File no. SF18/9026
DOC No: DOC18/63089

WestConnex M4-M5 Link (SSI 7485) – Comments on Response to Submissions

Tim Smith OAM
Director Heritage Operations
Heritage Division
Office of Environment and Heritage
As Delegate of the Heritage Council of NSW
20 February 2018

Figure 2-12 Iron Cove Link Master Plan

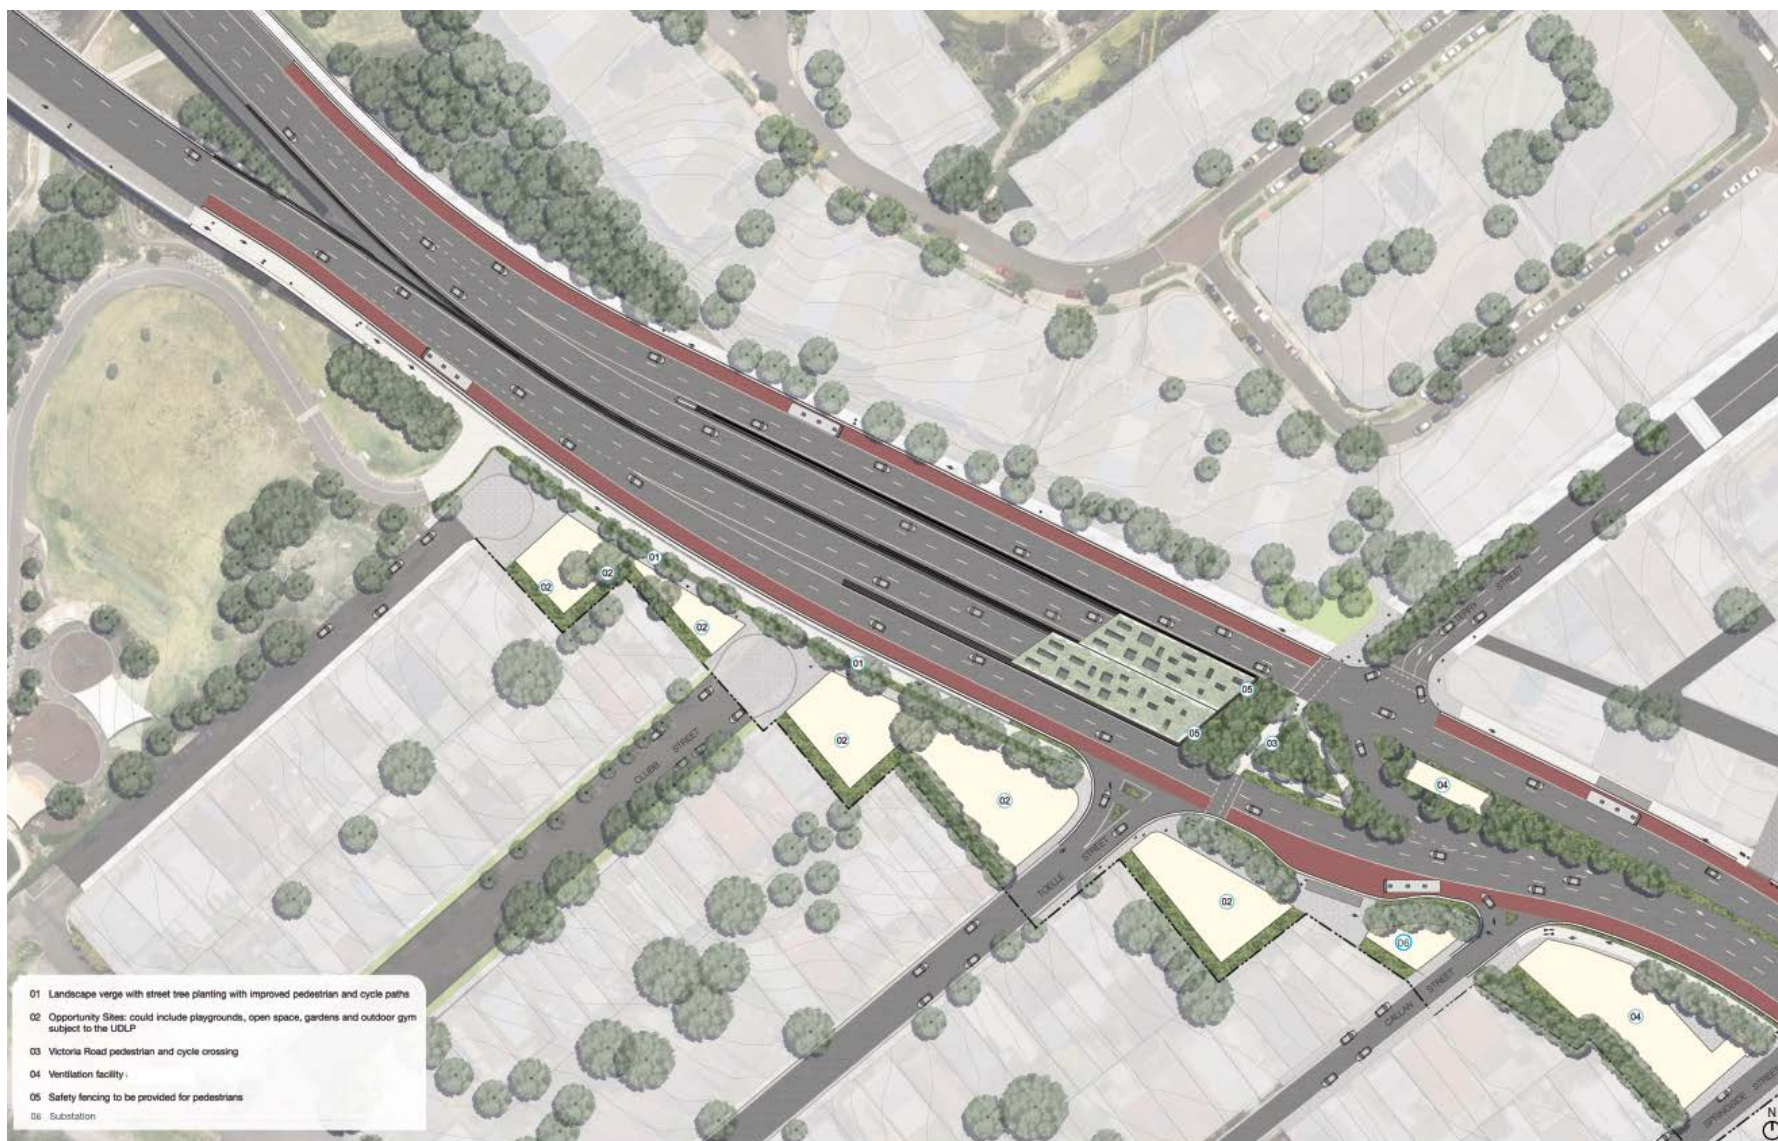
It is understood the design of the ventilation outlet at the Iron Cove link has yet to be finalised and will be subject to further design refinement including to reduce the height, bulk, scale and enhance the landscape setting of ventilation outlet. This must be undertaken in

consultation with the Heritage Council or its delegate, to ensure its design and placement gives consideration to the surrounding character and setting including the adjacent Iron Cove Heritage Conservation Area.

Figure 20-15 Listed and potential heritage items directly impacted at Rozelle, Lilyfield and Annandale

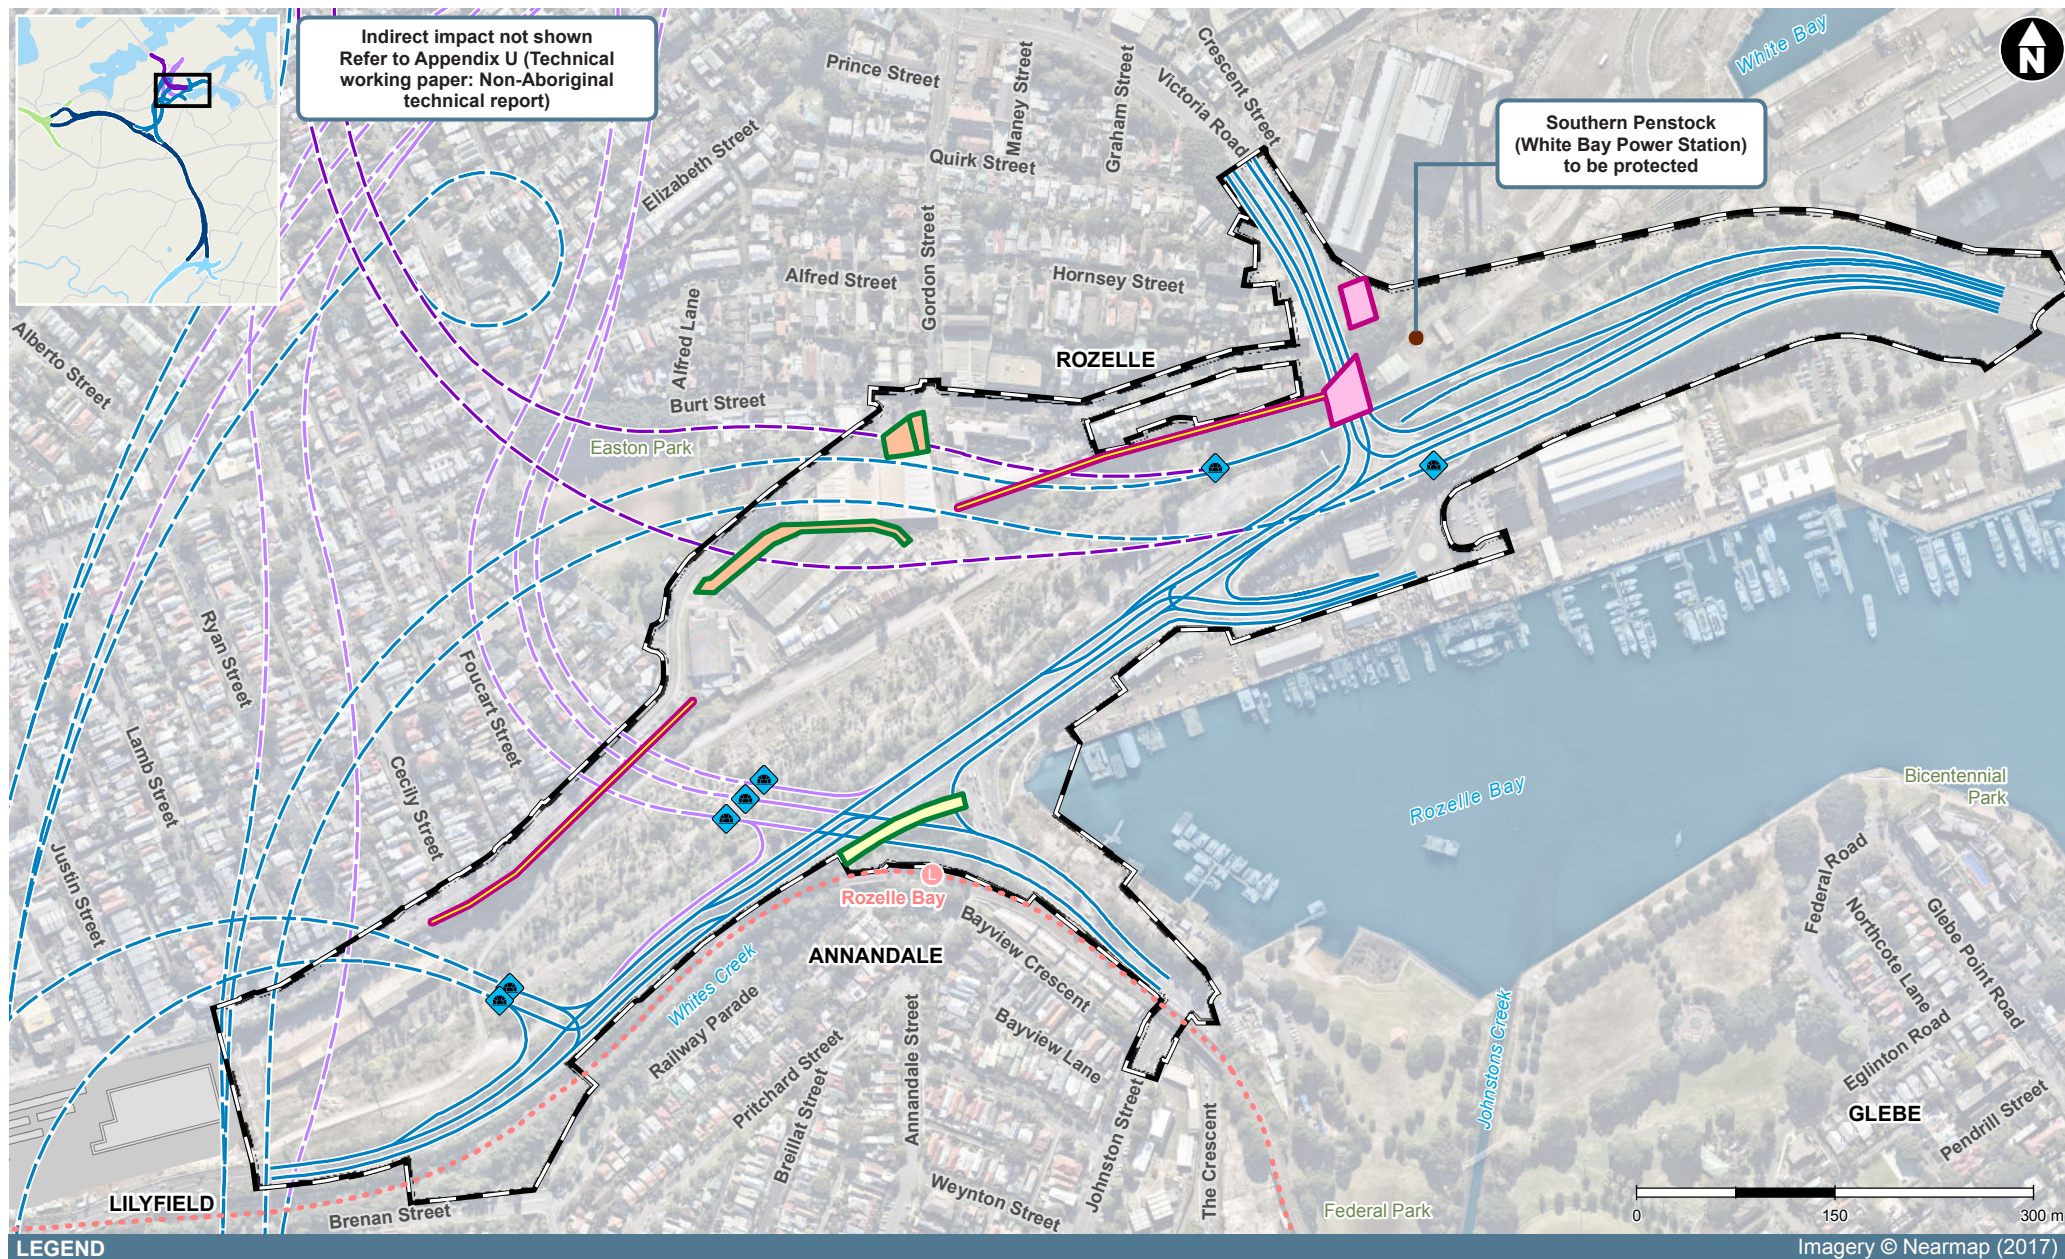
The late nineteenth century Cadden Le Messurier and the 1878 Former Hotel have been identified as items of heritage significance (SREP No 26). These items also contribute to the streetscape of Lilyfield Road. Their demolition is not supported.

The response notes the demolition of these two heritage listed items is necessary due to proximity of tunnelling immediately adjacent to the buildings, and the need to locate underground services in this area.

However, it is understood detail design development is still being undertaken. It is therefore premature to give approval to demolish these significant heritage items prior to adequate detail design work being undertaken. It is therefore recommended that the project footprint is realigned during detailed design stage to exclude these properties from the works area.

It is understood that the former Bank of NSW building is not listed on any current statutory heritage list. However, it has been identified as having potential local heritage significance. It is also identified as being rare in the context of Parramatta Road as an example of a purpose built inter war commercial building. The proposed demolition of this Inter-War commercial building will result in the significant loss of a landmark building. It will also adversely impact the character of the streetscape. Therefore, demolition is not supported.

The response does not adequately justify why the temporary construction zone cannot be revised to exclude this building from the construction site. It should be noted the footprint of the building is relatively small in comparison to the overall tunnelling site. Further, the response does not justify why the demolition of this building for a short-term activity is appropriate.

As the Heritage Council's concerns have not been sufficiently addressed, it is still recommended the project footprint is amended to retain the former Bank of NSW building.

The storage warehouse building at 79 Pyrmont Bridge Road, contributes to the industrial streetscape along Pyrmont Bridge Road. It is understood, due to the large footprint of the building, that the full retention of this building will limit the temporary construction site. It is therefore recommended that a significant portion of the building fronting the street of the storage warehouse building be retained to ensure impact to the character of the streetscape is minimised.

Figure 20-16 Listed and potential heritage items directly impacted at Victoria Road (east of the Iron Cove Bridge)

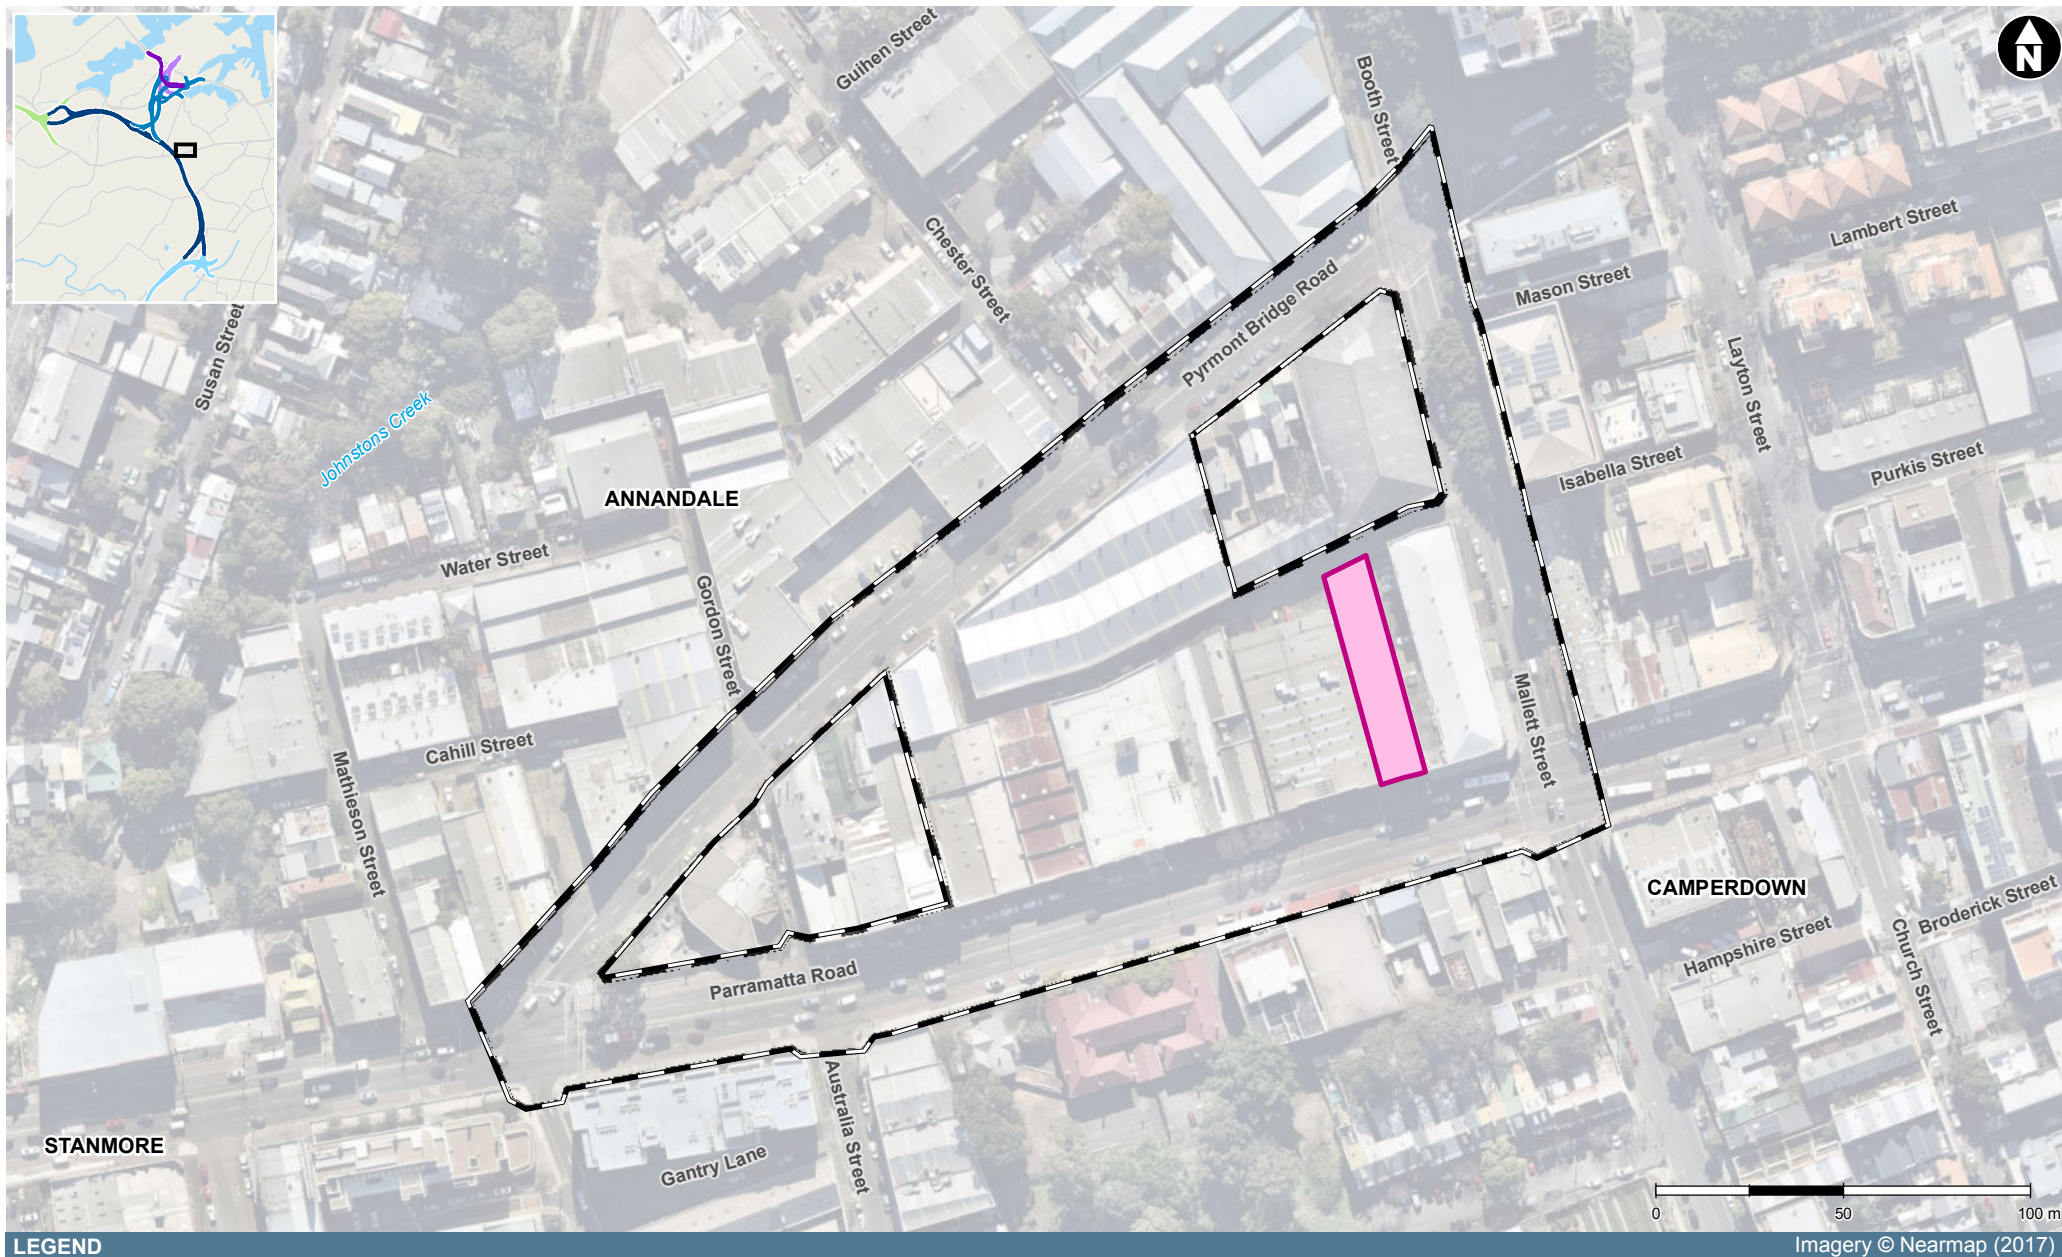
The proposed demolition of six buildings along Victoria Road, identified as being of potential local heritage significance, is not supported as it would diminish the character of the area. Further, we are concerned that adequate assessment of other potential heritage items has not been undertaken.

The response notes the property at 244 Victoria Road Rozelle was not accessed for its potential heritage significance due to it being obscured by tall fencing and vegetation. This was only raised in response to an Inner West Council comment. It is recommended a comprehensive assessment is undertaken to ensure all items of potential heritage significance are identified, then an assessment be undertaken of the potential impacts of the proposed works.

Should approval for demolition be granted, the Heritage Salvage Strategy proposed as part of the works, must be prepared prior to demolition works commencing. It must be developed in consultation with a heritage consultant and identify appropriate salvage processes including storage procedures on site. Further, workers on site must be made aware of identified items to be recovered to ensure these elements are safeguarded for reuse/relocation.
